DRB Application No . 09DRB-70019 Project # 1007551
 Project Name: HUBBELL PLAZA
 Agent GREAT BASIN ENGINEERING Phone No (801) 521-8529

City of Albuquerque
Planning Department
Inter-Office Memorandum

TO: Jack Cloud, DRB Chair
FROM: Randall Falkner, Planner
SUBJECT: Project # 1007551

DEVELOPMENT REVIEW BOARD – SPEED MEMO

12 Feb, 2009  
 SHEET NO. **1a**

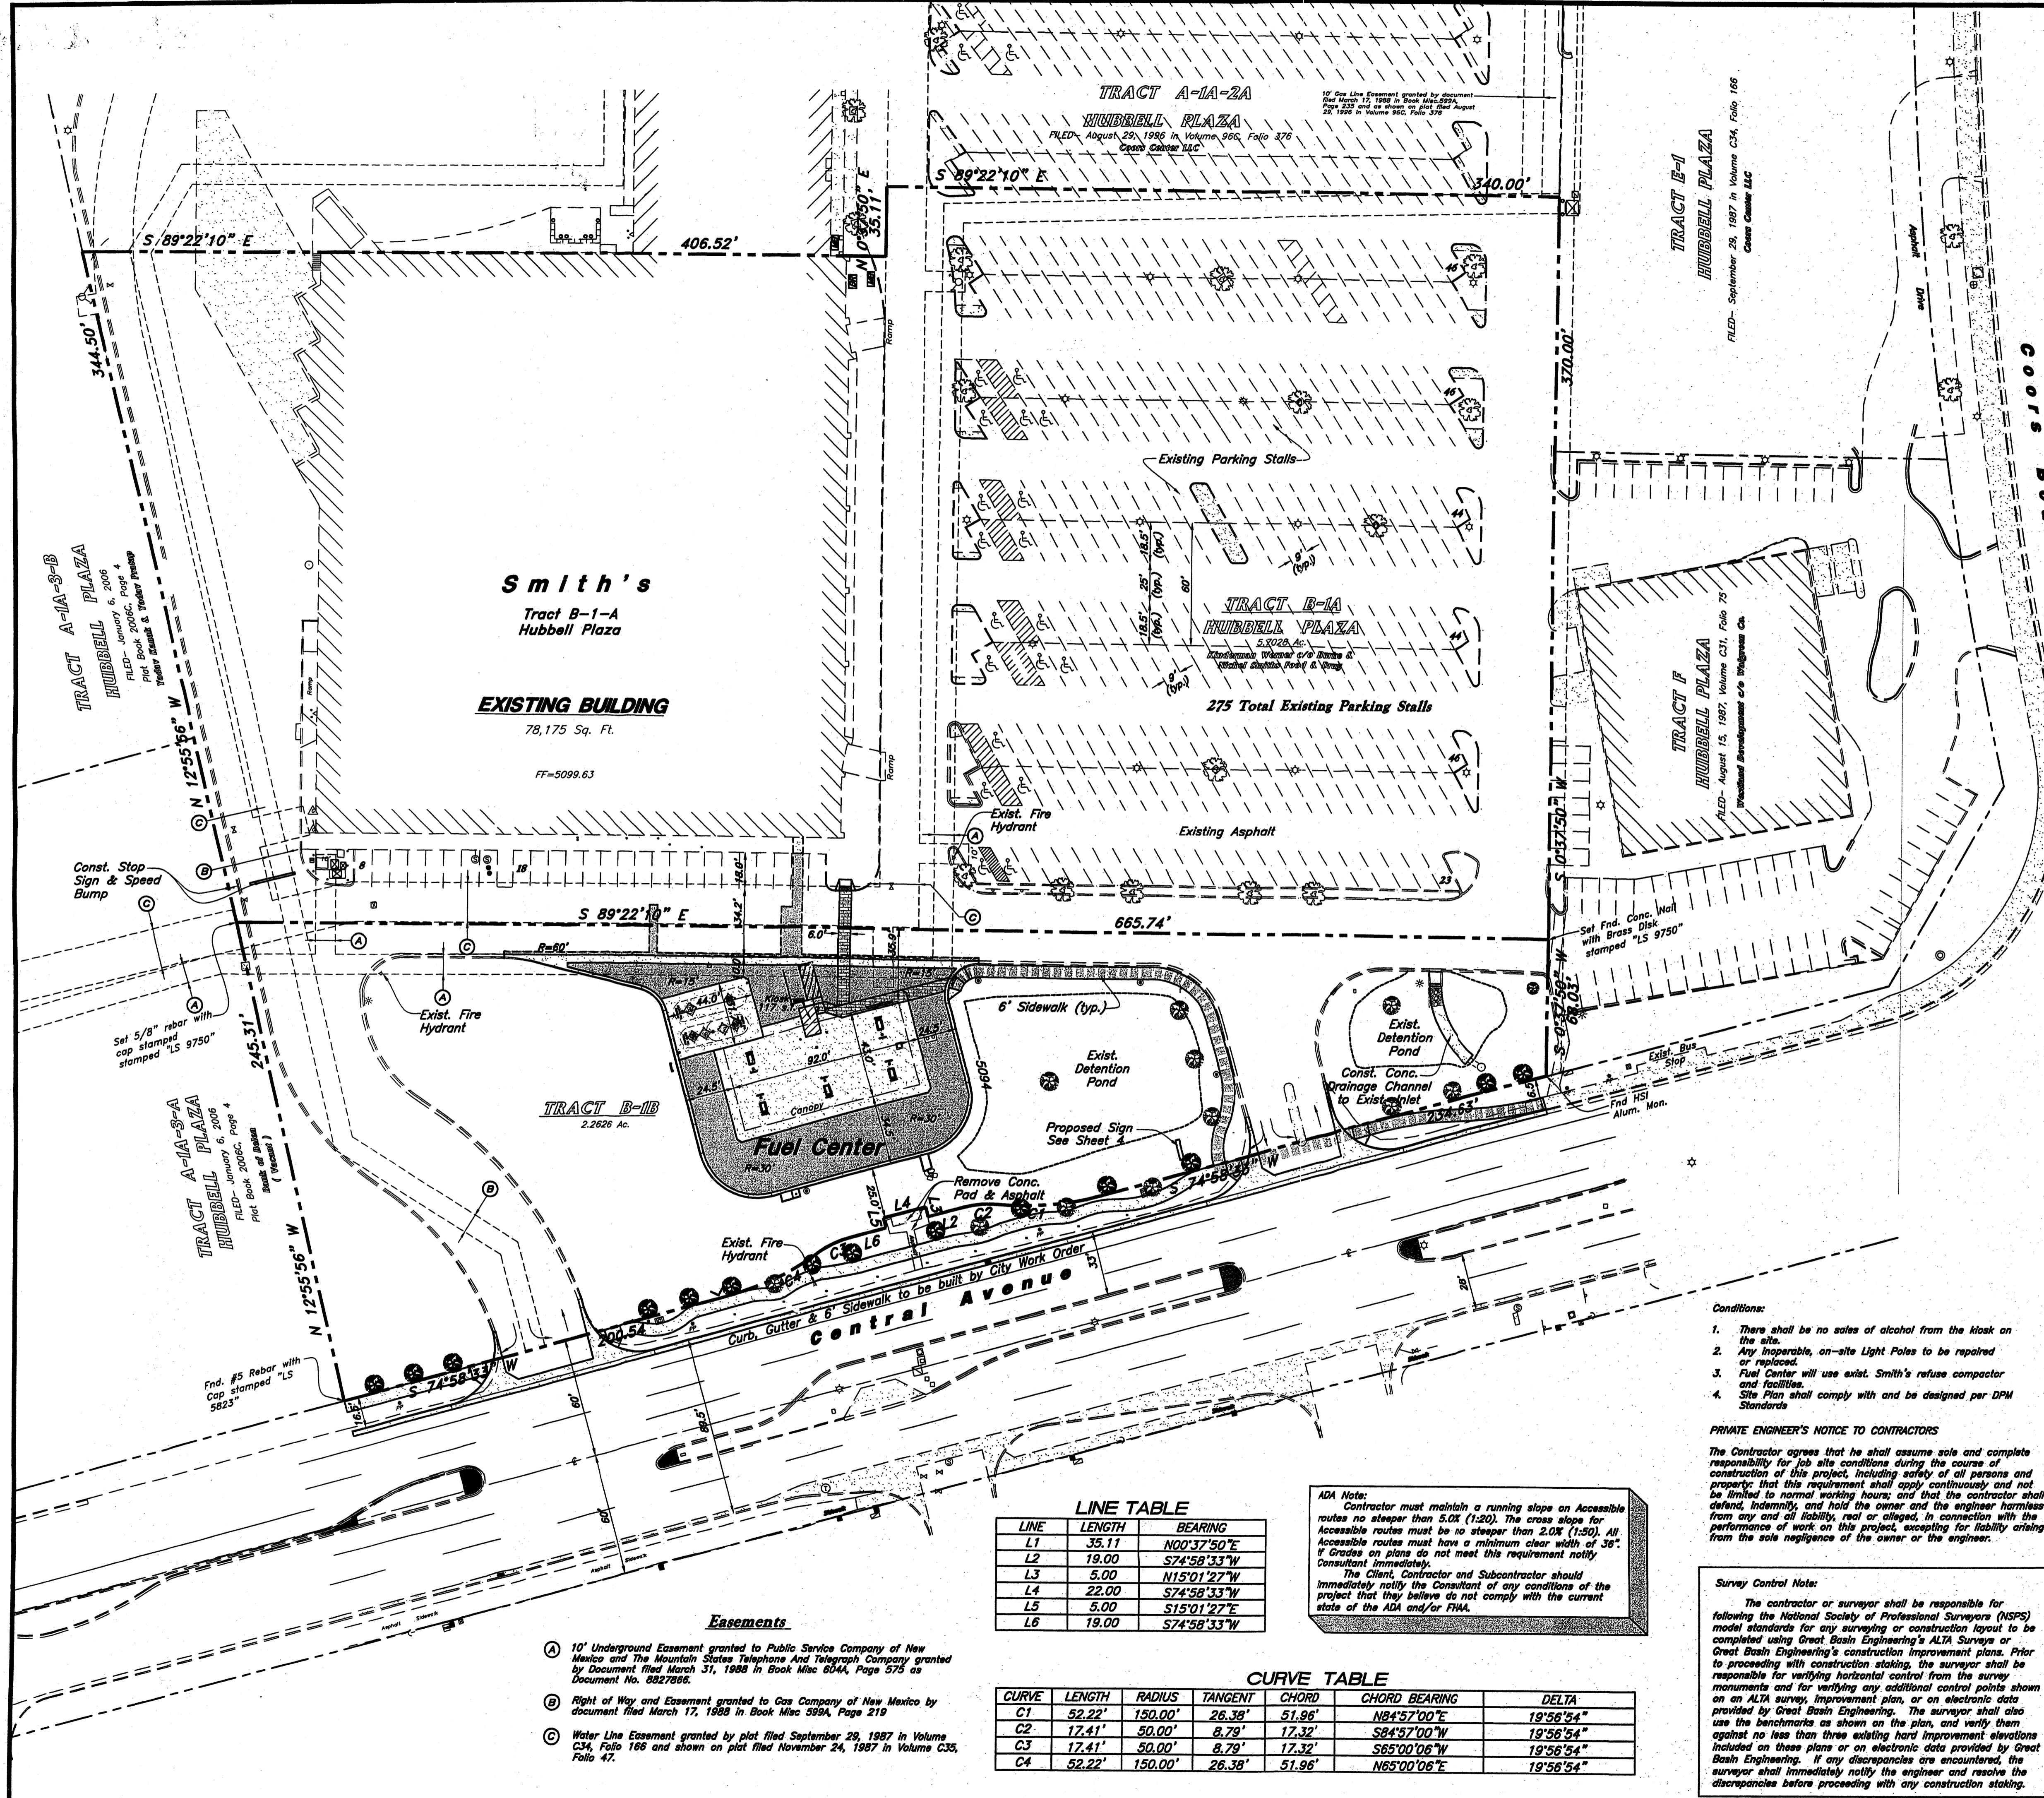
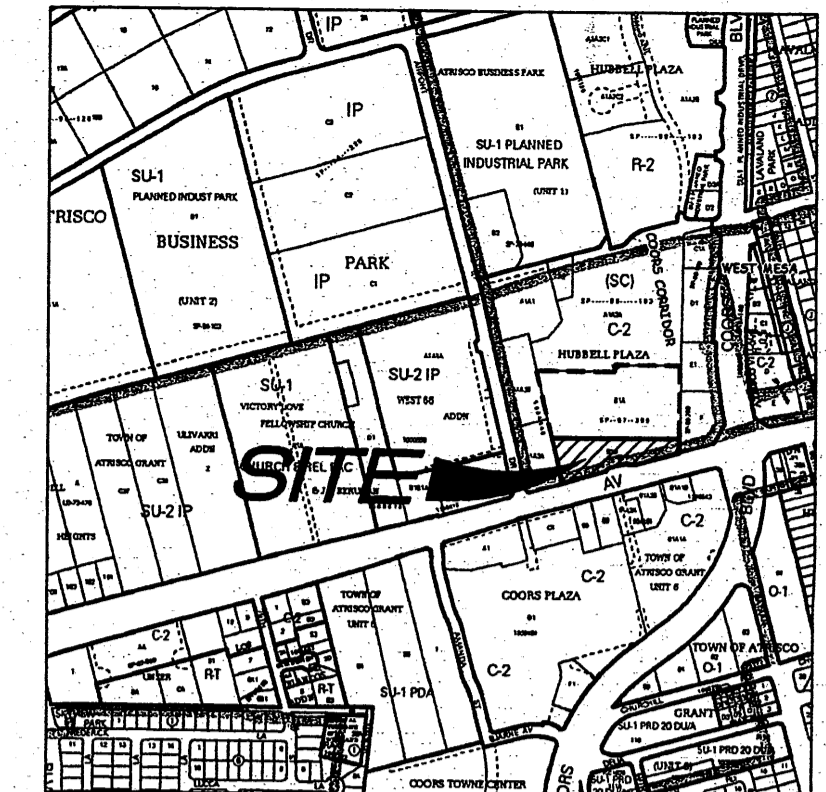
- ✓
1. Condition 10b calls for all crosswalks and sidewalks to be a minimum of 6 feet in width. Sheet 1b shows the crosswalk between Smith's and the Fuel Center as being 6 feet wide; however, Sheet 1a shows the this crosswalk as being only 5 feet wide. Both Sheets 1a and 1b need to be consistent.
 2. Although not a condition, the Zoning Code requires trees to be a minimum of 10 feet tall at installation, per Section 14-16-3-10(F)(1). The Afghan Pine on the landscape plan is listed as 6'- 8' tall.

Provide an exhibit showing the location of sidewalk and defining the distance from face of curb to the property line. Right of way dedication may be required.
The significant hatching obstructs the plans clarity and makes the plan difficult to read. Please clarify existing versus proposed conditions.
Geometric information must be provided.
Sidewalk and curb and gutter is required along Central Avenue.
All public sidewalk located outside of the City right of way must be located within a public sidewalk easement.

Comments have been addressed as requested and Curb, Gutter and Sidewalk have been added to the Central Avenue frontage and an Infrastructure list has been prepared for these improvements. Drainage notes have been added to address Public storm water draining on to the site as requested by hydrology.
